LU/14/22/DOC

1 Arcade Road Littlehampton BN17 5AP

Approval of details reserved by condition imposed under LU/310/18/PL relating to condition 3-schedule of materials and finishes.

Cedral Lap

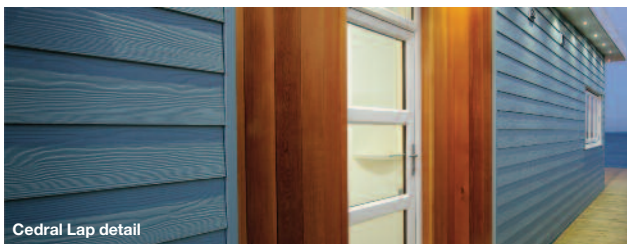
I have visited the building concerned and have noticed that works have commenced. This includes the new cladding on one of the side elevations. I have noticed that the cladding is being installed on horizontal basis

as opposed to vertical one as identified in the approved plans. I was under the impression that the new boarding would be more appropriate for the context. Whilst the use of slate seems to be acceptable, as a conservation officer I would prefer for the cladding to be timber as opposed to modern cementitious materials.
